# MONA OFFSHORE WIND PROJECT

## Response to Section 51 advice

Document Reference: A6

April 2024

Drawing Number:
12079-0593-16

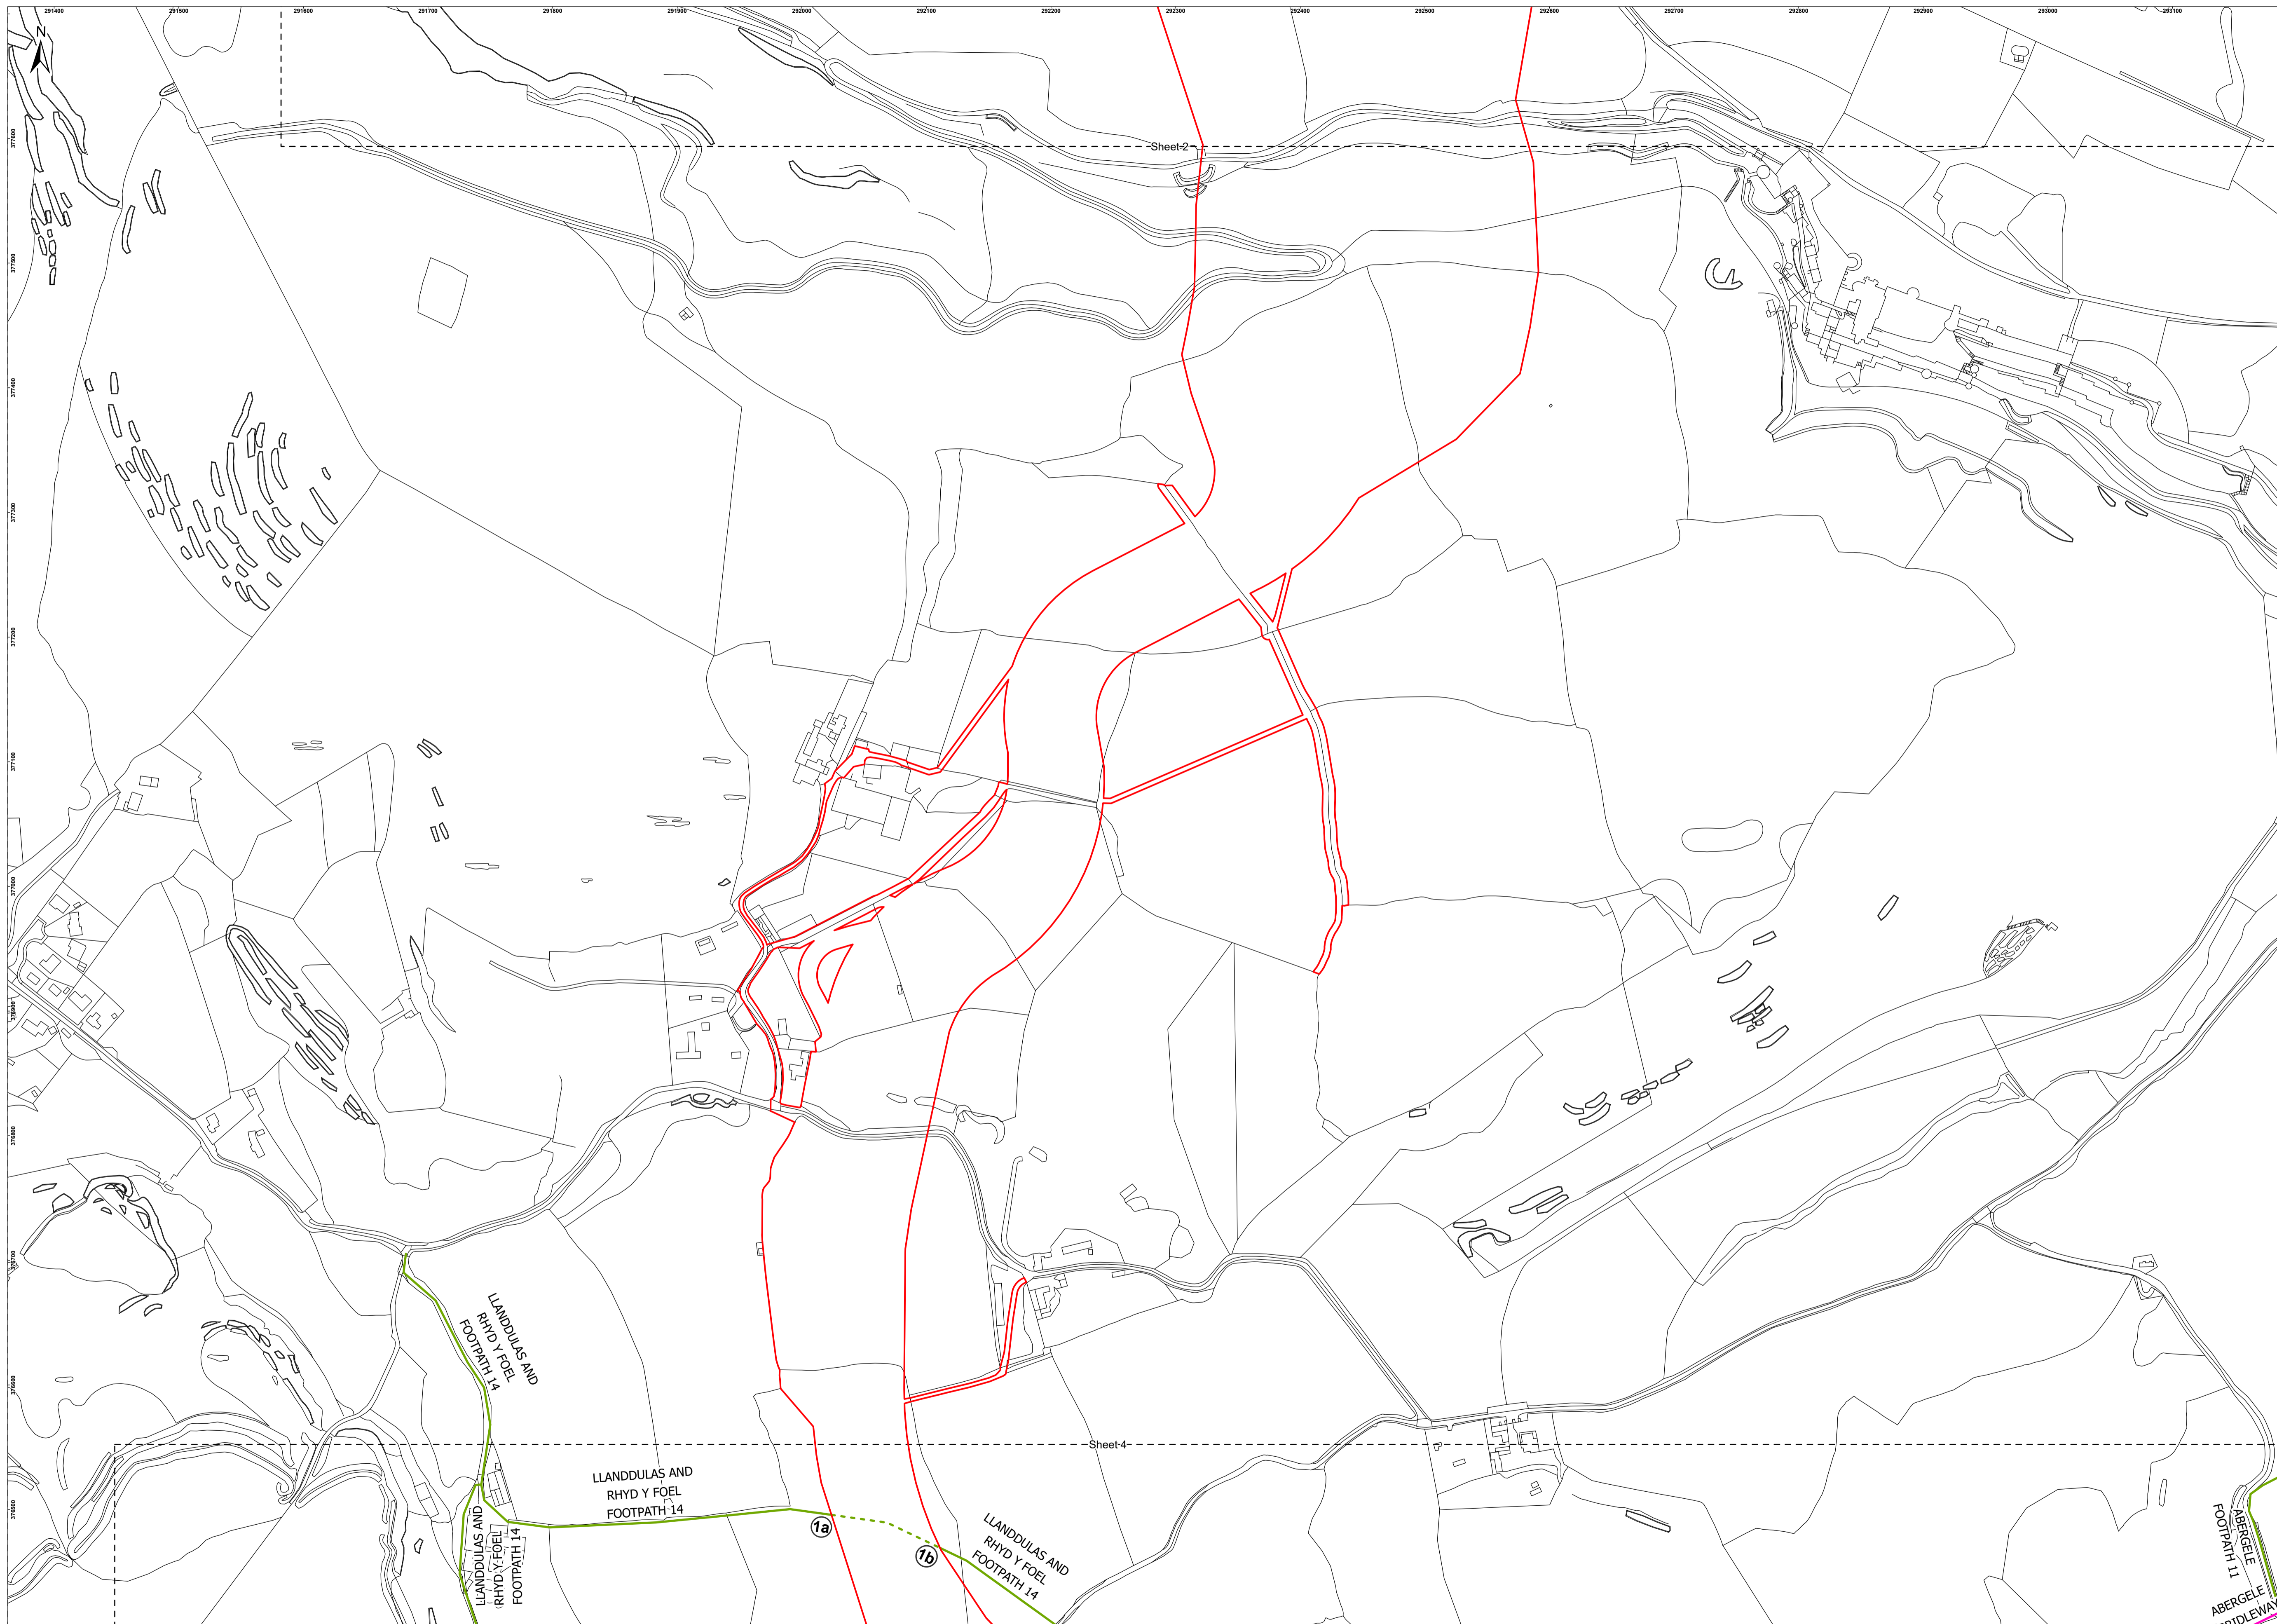
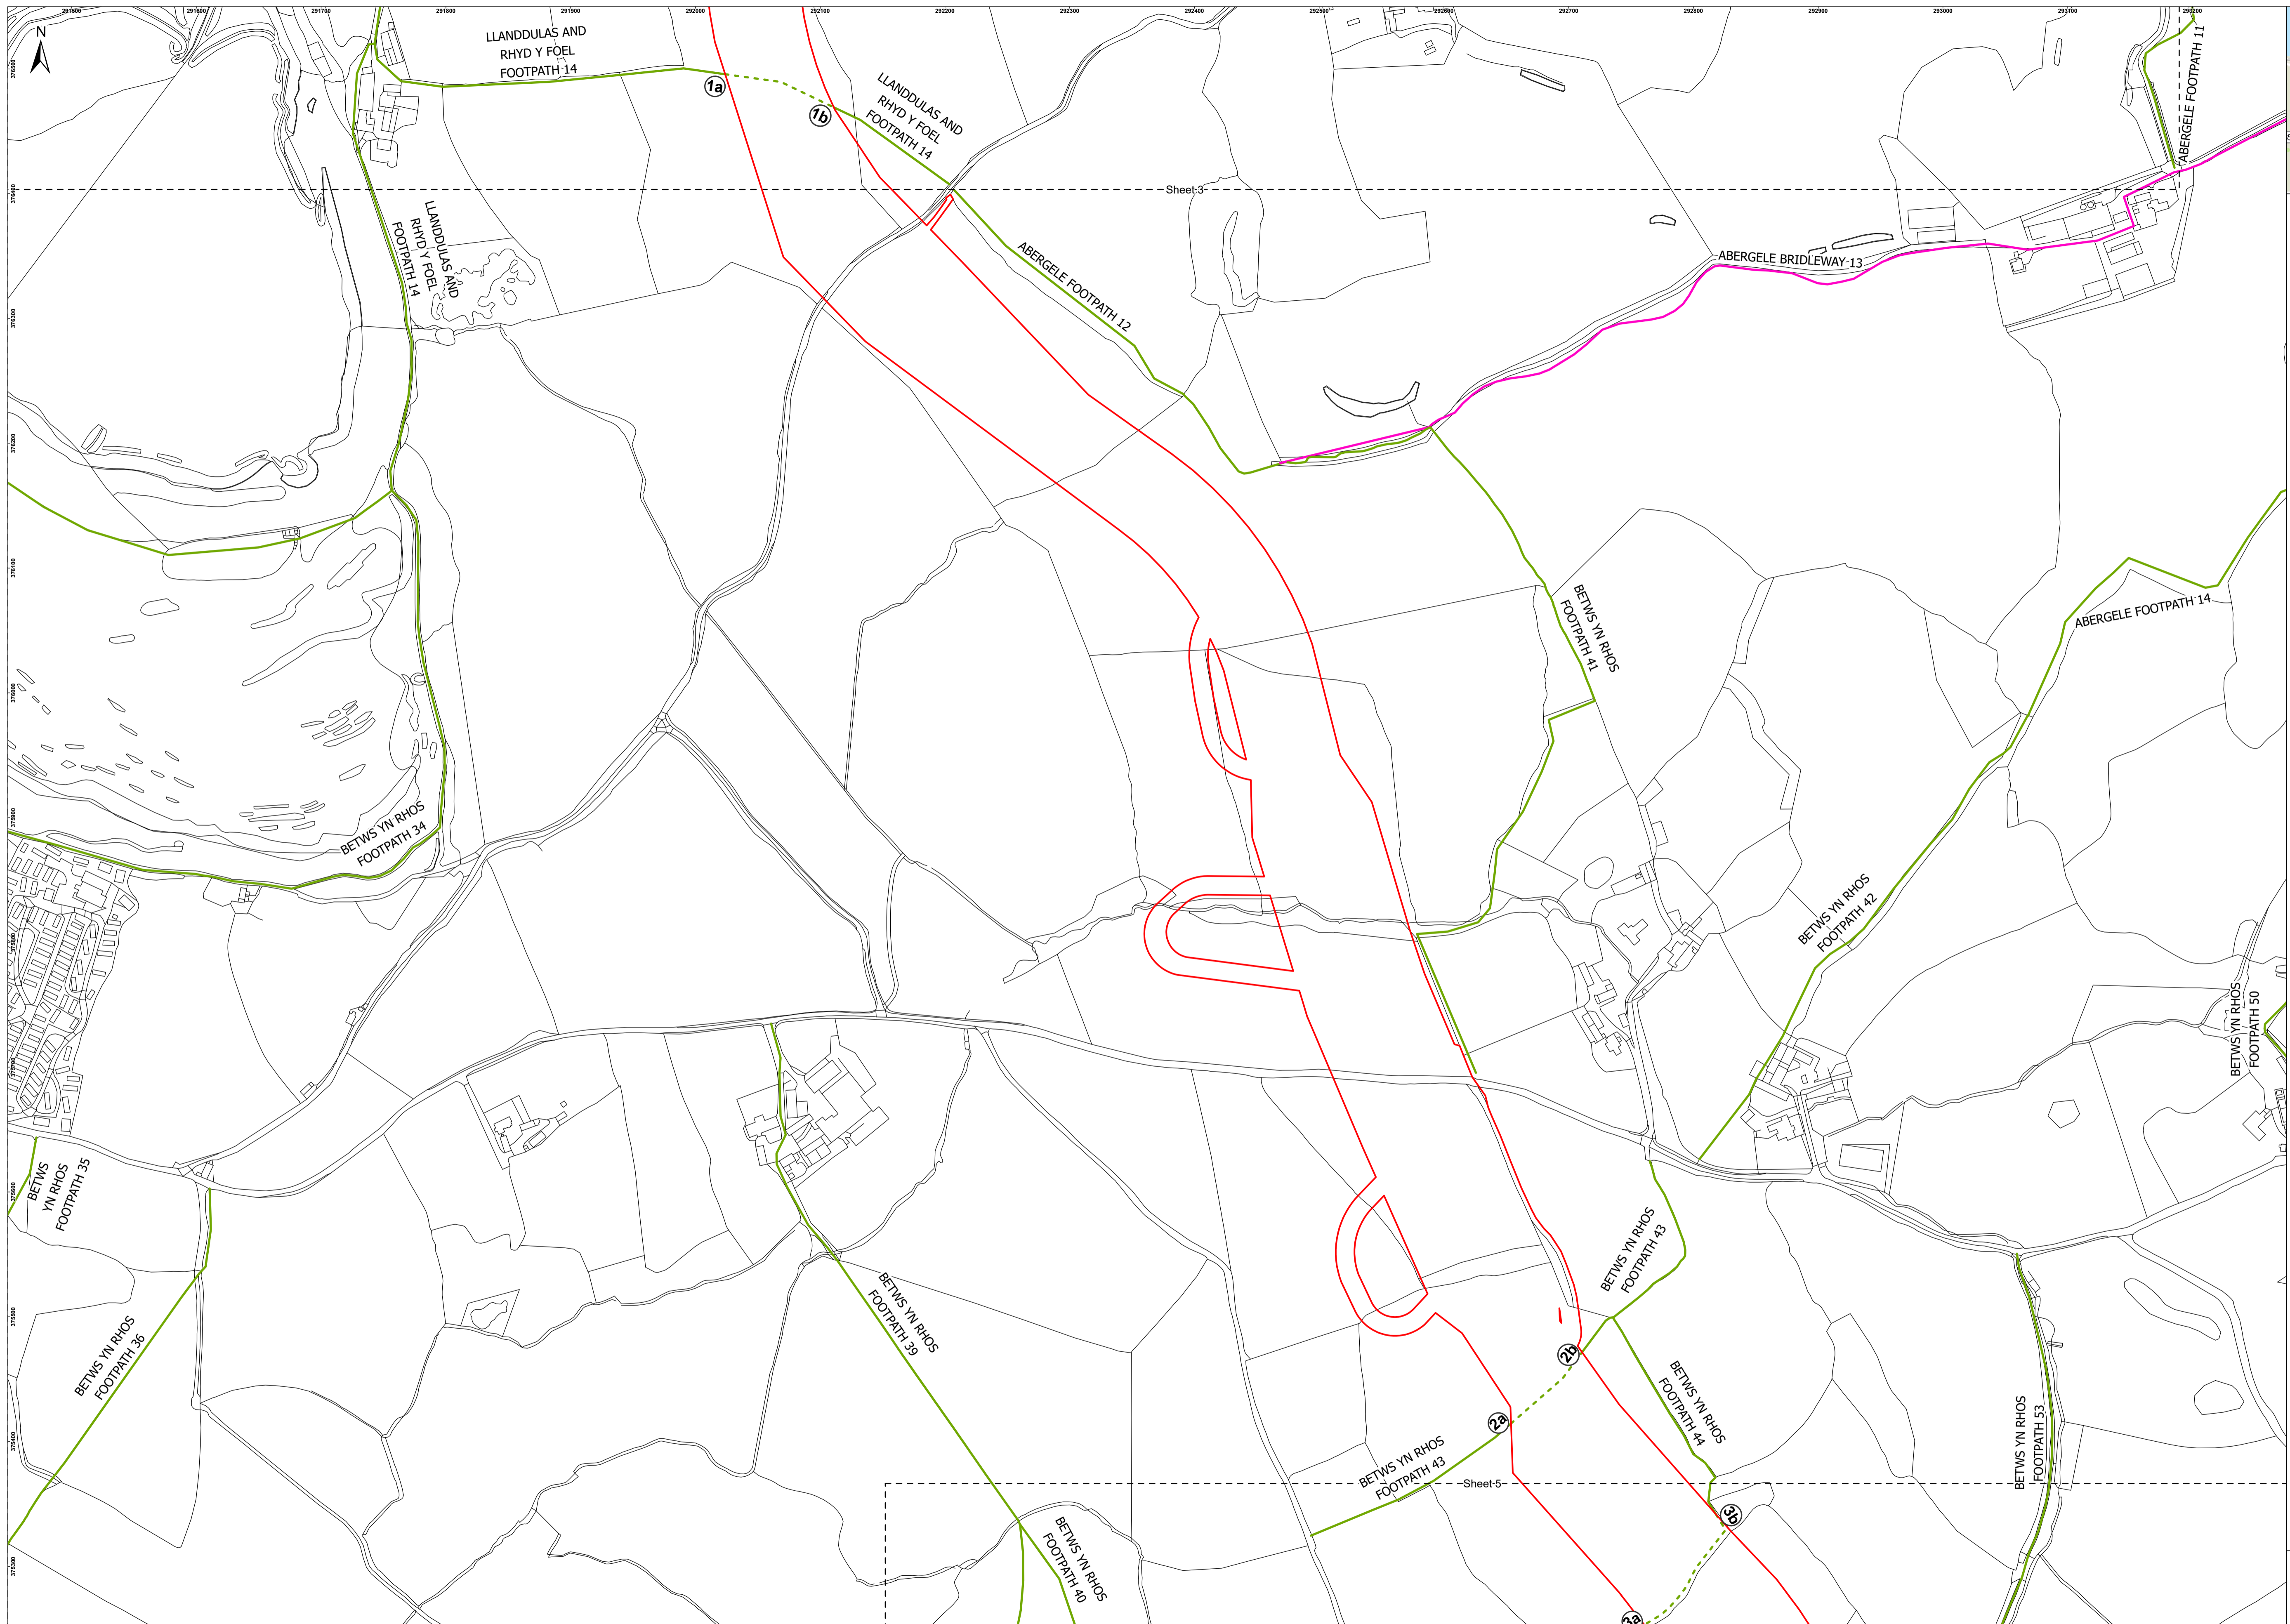
Topic	Section 51 advice	Applicants response
Observation in documents	Land Plan (Onshore) (Doc B5) Missing north facing arrow. Inset 5 (page 10) appears to use the wrong shade of green. For clarity, this should be corrected to use the same green as that in the legend.	This has been amended and the revised Land Plan (Onshore) (doc B5/F02) has been submitted to the Planning Inspectorate.
Observation in documents	Street Works and Access to Works Plan (Doc B15) Missing north facing arrow. The points on the plan (which are referred to in Schedule 3 and 4 of the DCO) could be slightly larger to aid comprehension. The points on the plan (which are referred to in Schedule 5 of the DCO) could be slightly larger to aid comprehension	These have been amended and the revised Street Works and Access to Works Plans (doc B15/F02) has been submitted to the Planning Inspectorate.
Observation in documents	Temporary Stopping up of Public Rights of Way Plan (Doc B16) Missing north facing arrow.	This amendment has been made and a revised Temporary Stopping up of Public Rights of Way Plan (doc B16/F02) has been submitted to the Planning Inspectorate.
